WEST SUSSEX COUNTY COUNCIL CONSULTATION

TO:	Arun District Council FAO: Amy Myer
FROM:	WSCC - Highways Authority
DATE:	17 November 2021
LOCATION:	47 Golden Avenue, East Preston, BN16 1QX
SUBJECT:	K/51/21/PL Erection of 1 No detached dwelling and integral garage. This site is in CIL Zone 4 and is CIL Liable as new dwelling.
DATE OF SITE VISIT:	N/A
RECOMMENDATION:	Advice
S106 CONTRIBUTION TOTAL:	N/A

| DRAWING TITLE<br>Proposed Block Plan and Street<br>Scene                                                                     |                        |

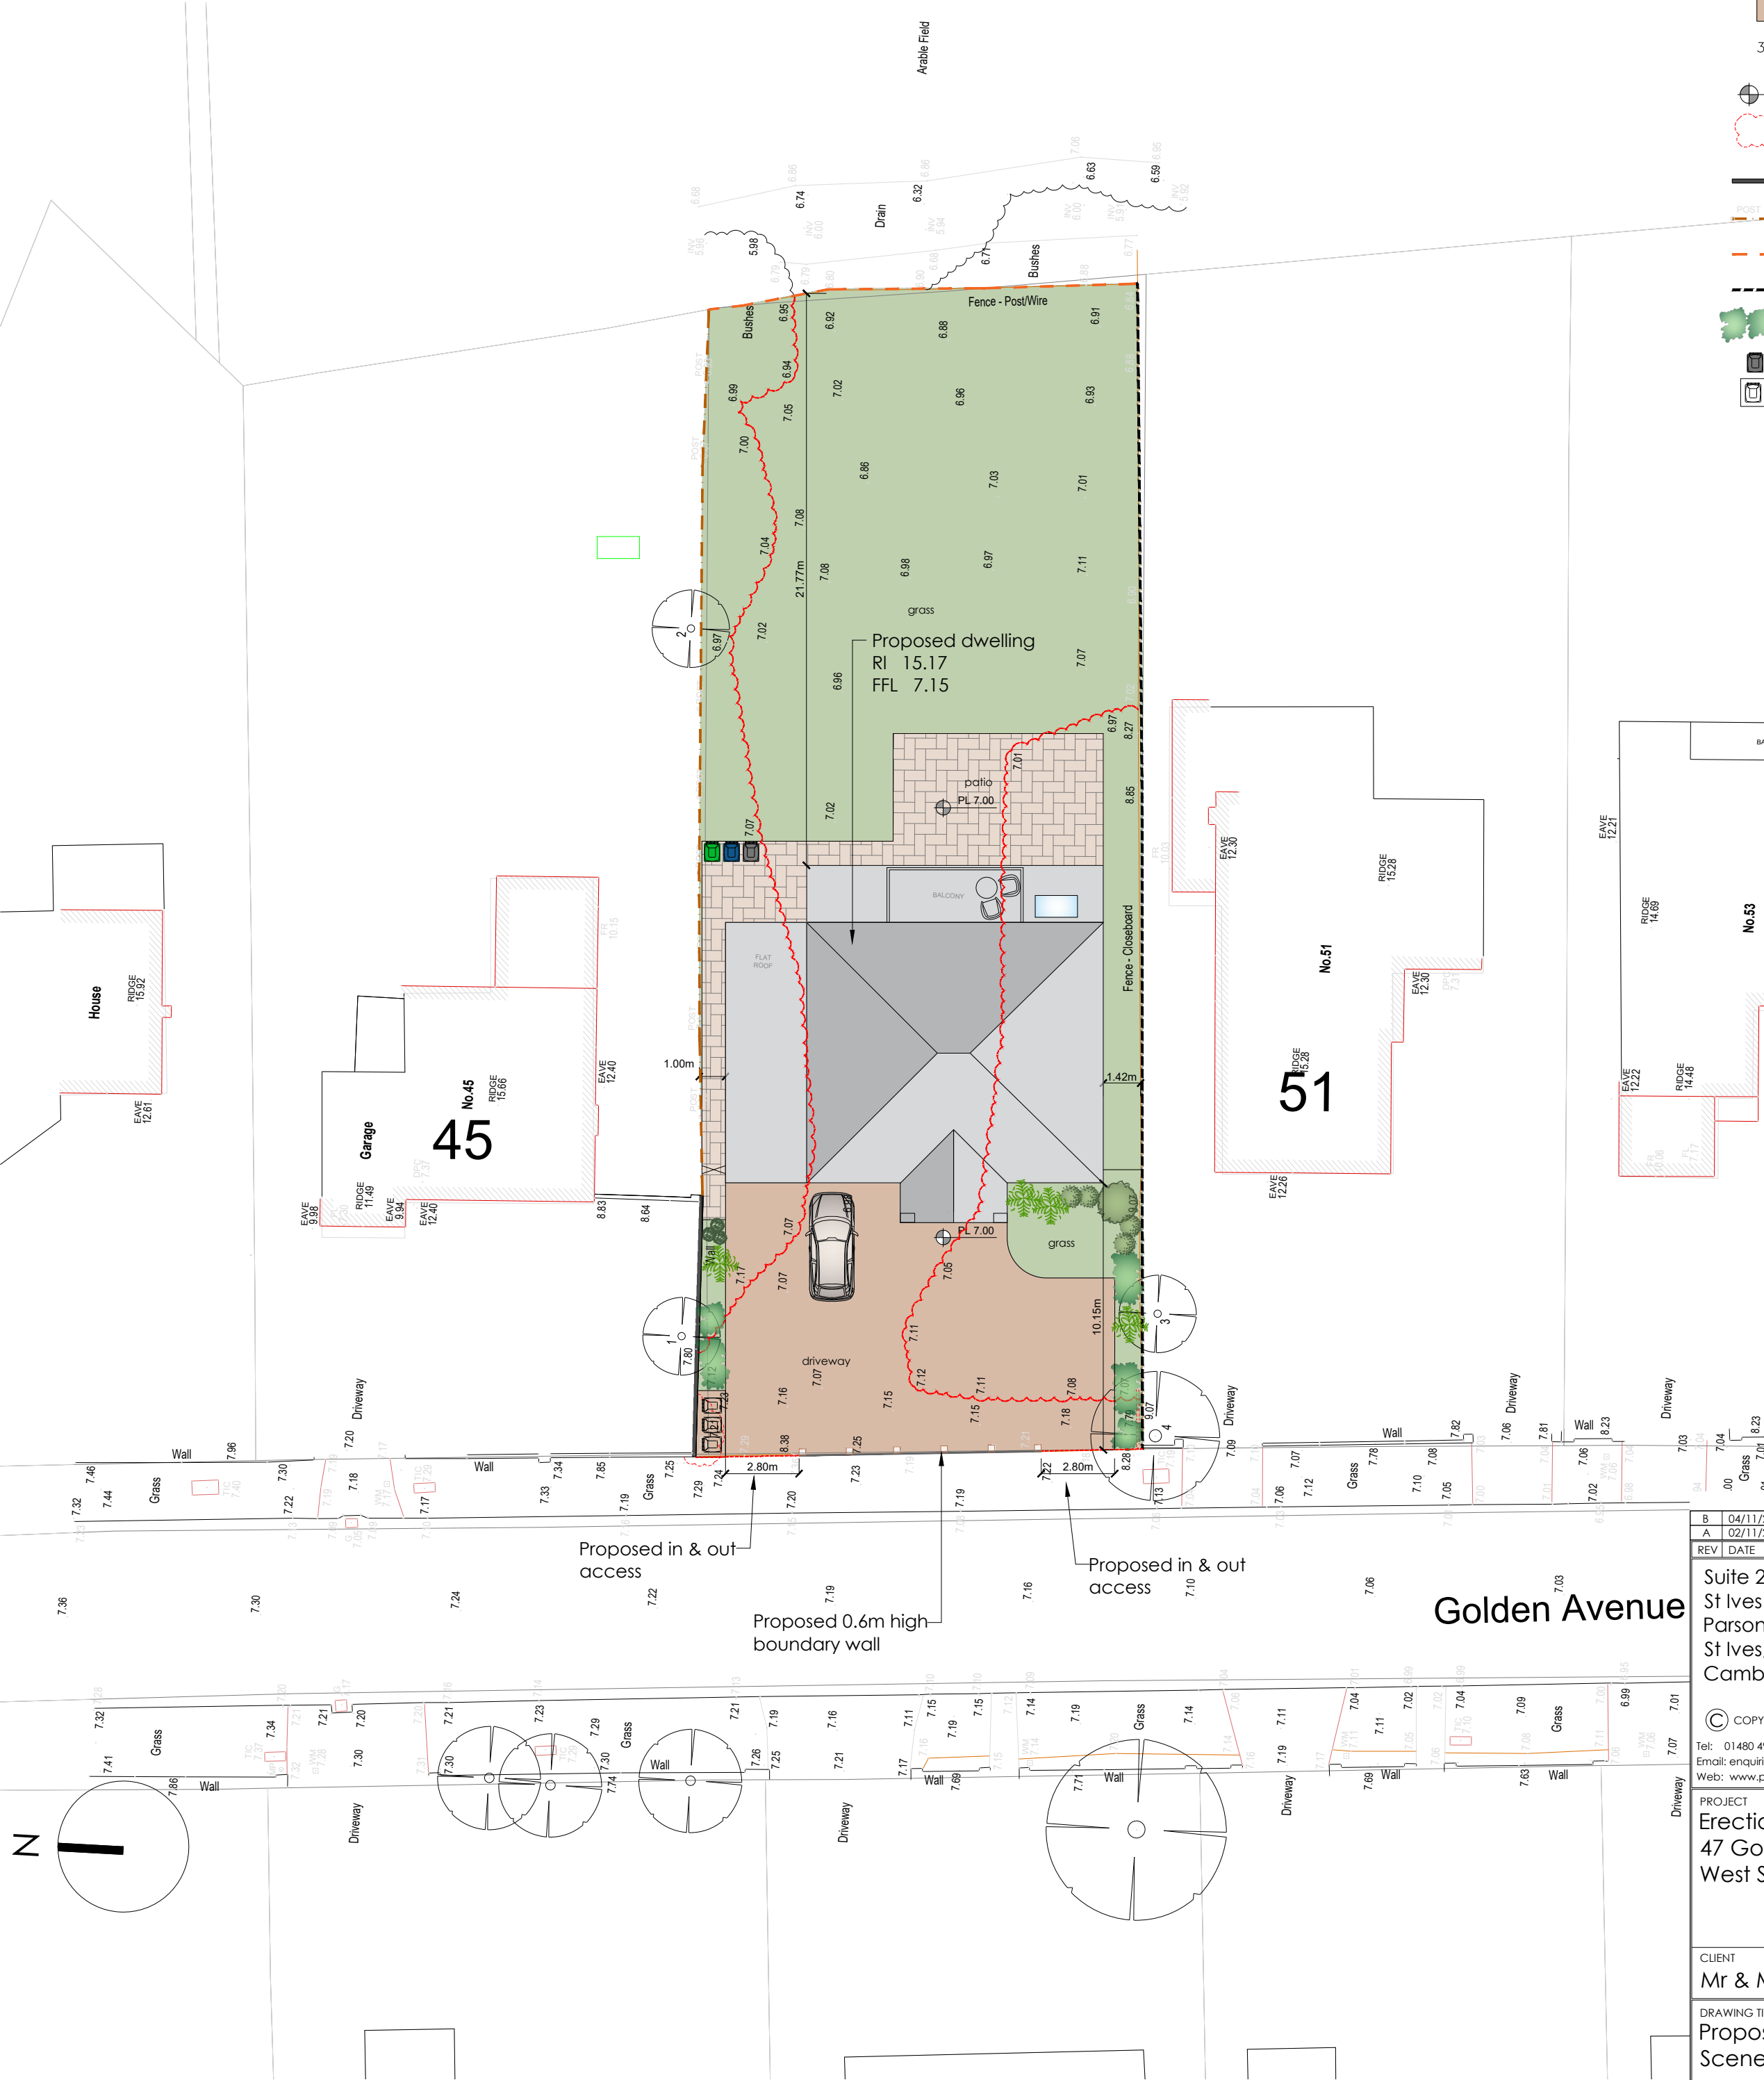
The applicant proposes a new in/out access onto Golden Avenue. The applicant is advised to contact the proprietor of the privately maintained road to obtain formal approval for the proposed access works. From inspection of the plans, there are no apparent visibility issues with the proposed points of access. The LHA does not anticipate that the addition of one dwelling would give rise to a material intensification of movements to or from the site.

For vehicular parking, the applicant proposes a double-bay integral garage with driveway. Under Arun Parking Standards, the LHA would expect a dwelling of this size in this location to provide at least three car parking spaces. Therefore, the LHA considers the proposed parking provision to be sufficient. From inspection of the plans, the garage and driveway are suitably sized to accommodate the parking requirement and on-site turning appears achievable.

Regarding cycles, the garage is of suitable size to be considered for secure cycle storage, in accordance with Arun Parking Standards. The inclusion of cycle parking helps promote the use of sustainable transport methods.
